From: Lauren Wiltshire [REDACTED]
Sent: 31 May 2019 11:30
To: Josh Ward [REDACTED]; Jon Ash [REDACTED]
Cc: Simon Davis <Simon.Davis@arun.gov.uk>; Laura Gibbons <Laura.Gibbons@arun.gov.uk>
Subject: RE: Planning Consultation on FP/42/19/DOC

From: Laura Gibbons <Laura.Gibbons@arun.gov.uk>
Sent: 31 May 2019 11:26
To: Lauren Wiltshire [REDACTED]
Cc: Simon Davis <Simon.Davis@arun.gov.uk>
Subject: RE: Planning Consultation on FP/42/19/DOC

1. The construction detail drawings of the attenuation tanks needs to show the impermeable membrane around the tank, between the tank and the coarse sand bedding. MJA to update
2. Can the catchpits please be labelled on plan. MJA to update
3. 3m easement is not being provided to the watercourse at plots 12, 13 and 14. Please can this be provided. Or as a minimum demountable fences provided. Yes landscaping to include on layout

Project: Wellers Close Hampshire Homes Group	
Drawing: Soft Landscaping Concept	
Date: May 2018	Drawn by: JA
Scale: 1:200 @ A1	Revision: -

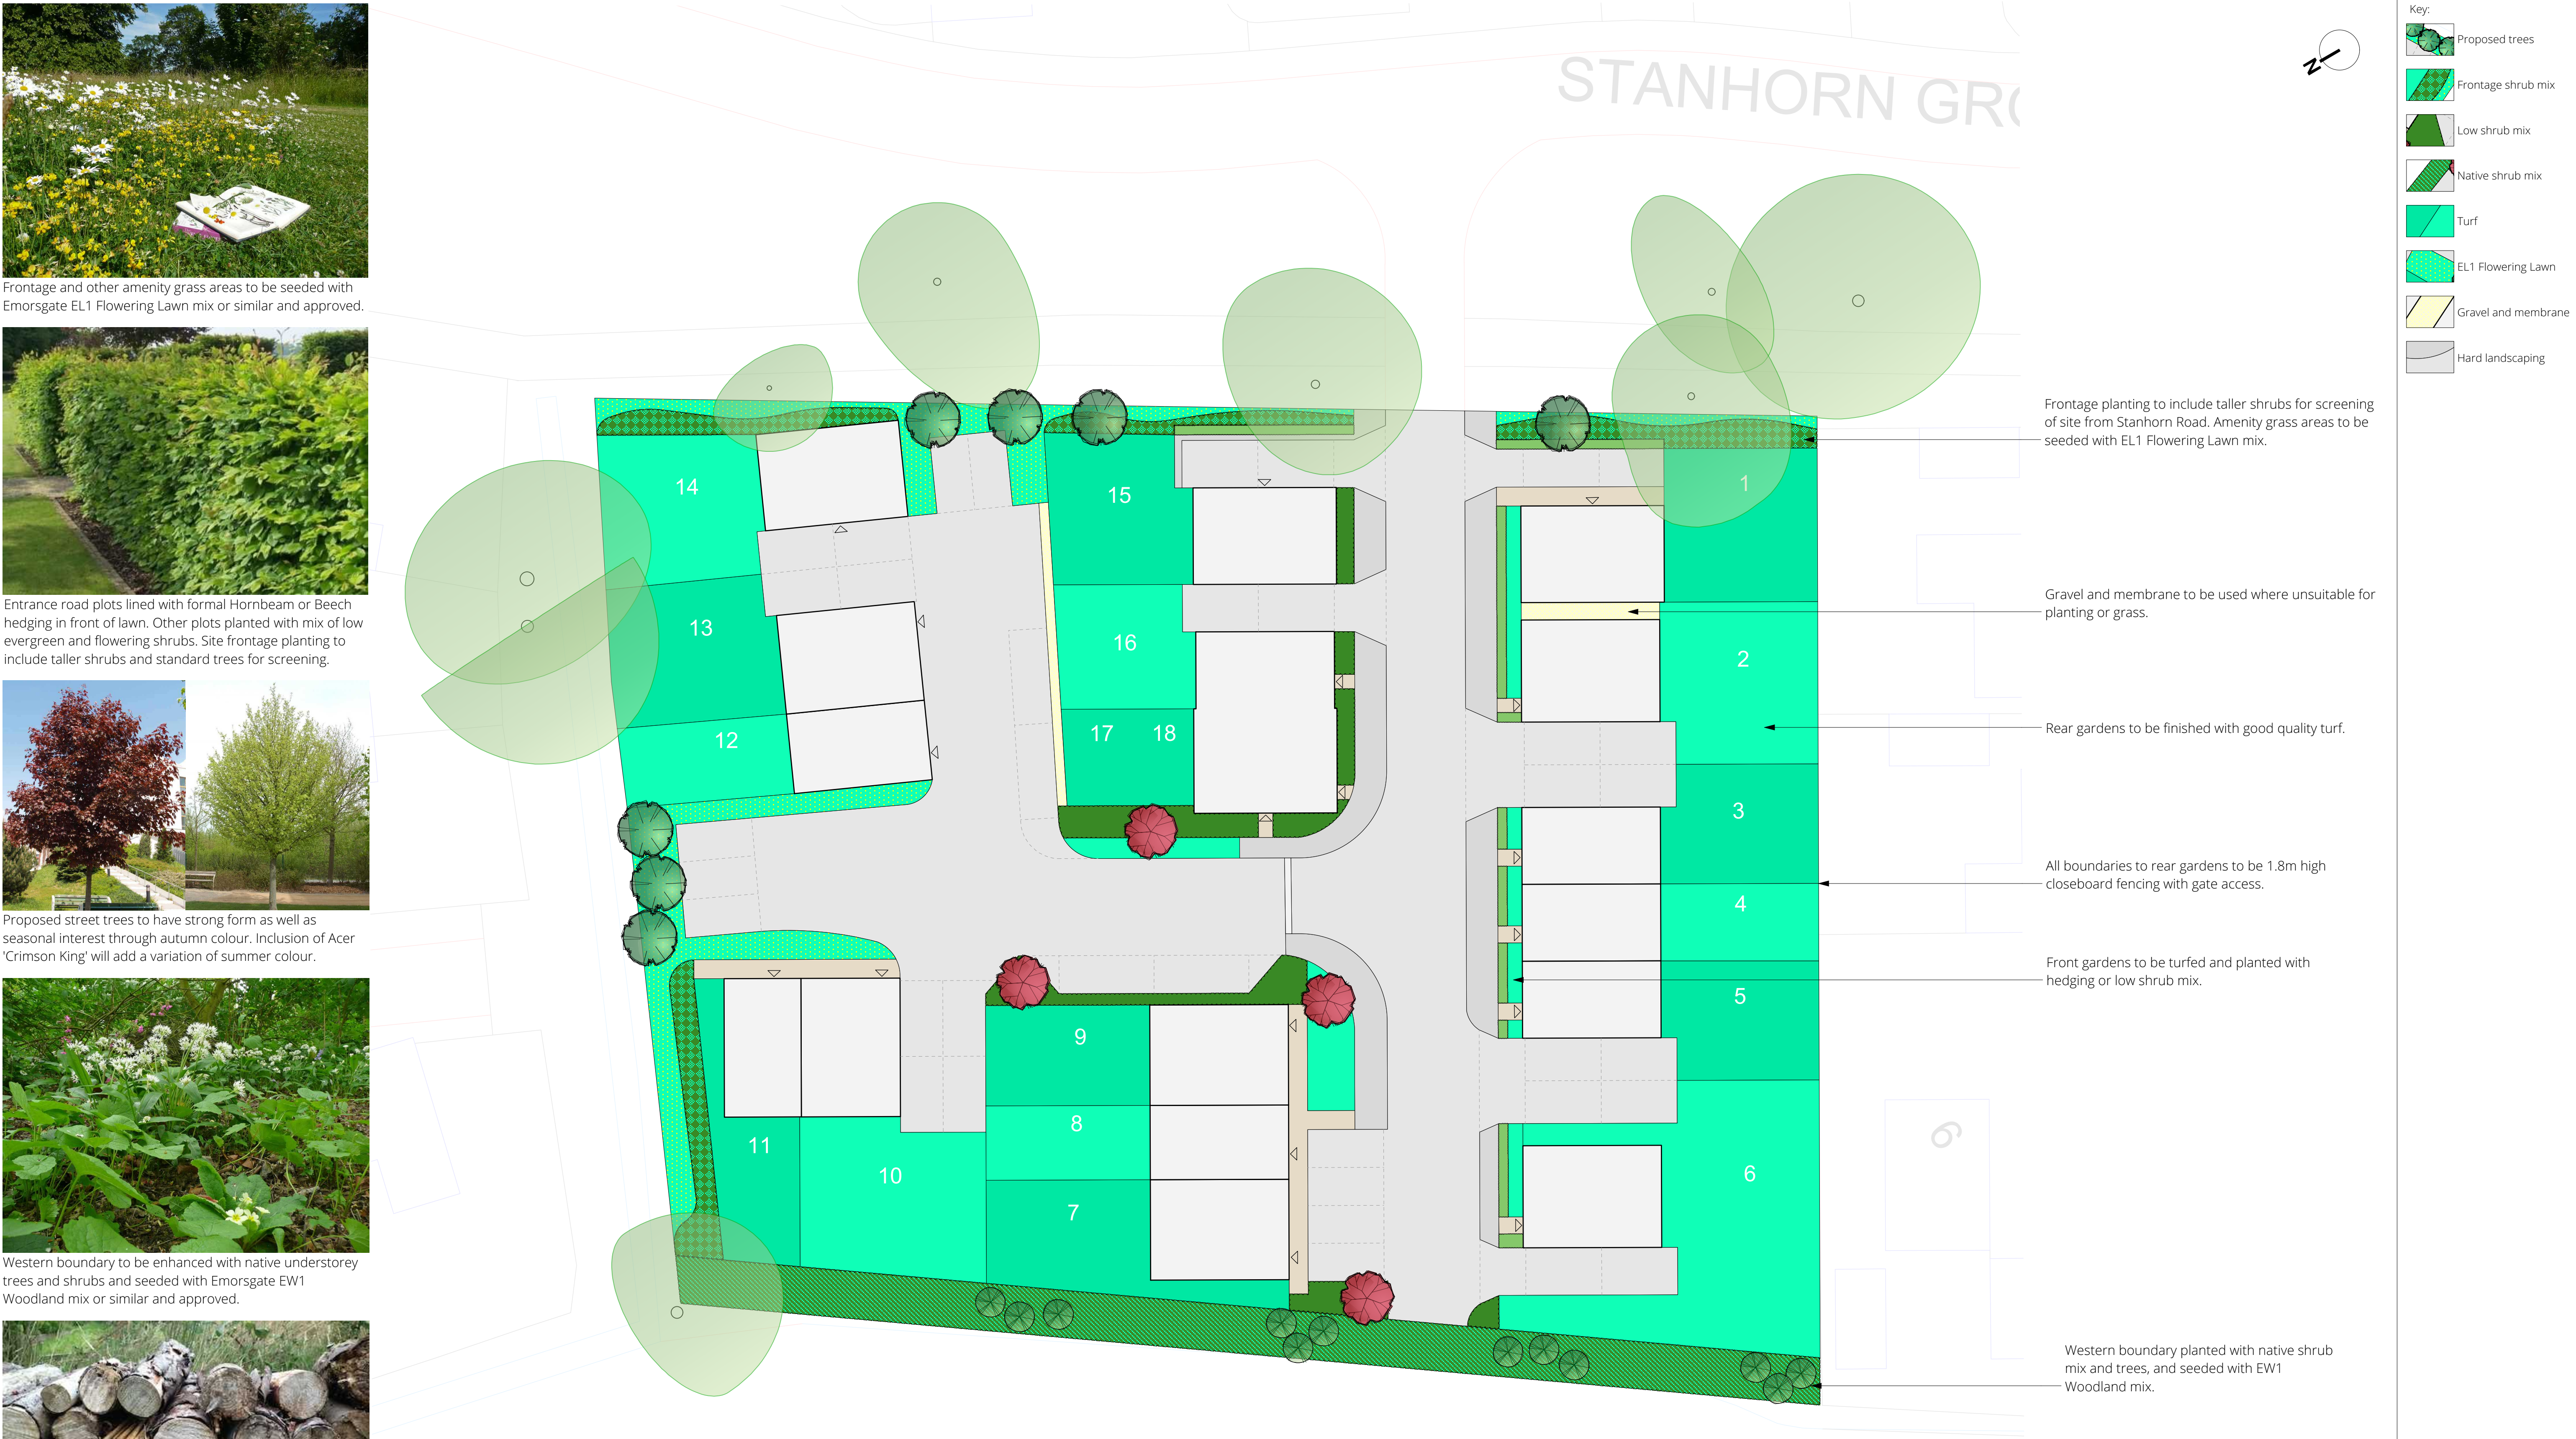
4. Please can the proposed landscaping plans be amended to remove the trees at the end of the parking area between plots 12 and 11/10? Trees are proposed directly in the location of the control chamber and in close proximity to the lined tank. Yes landscaping to update
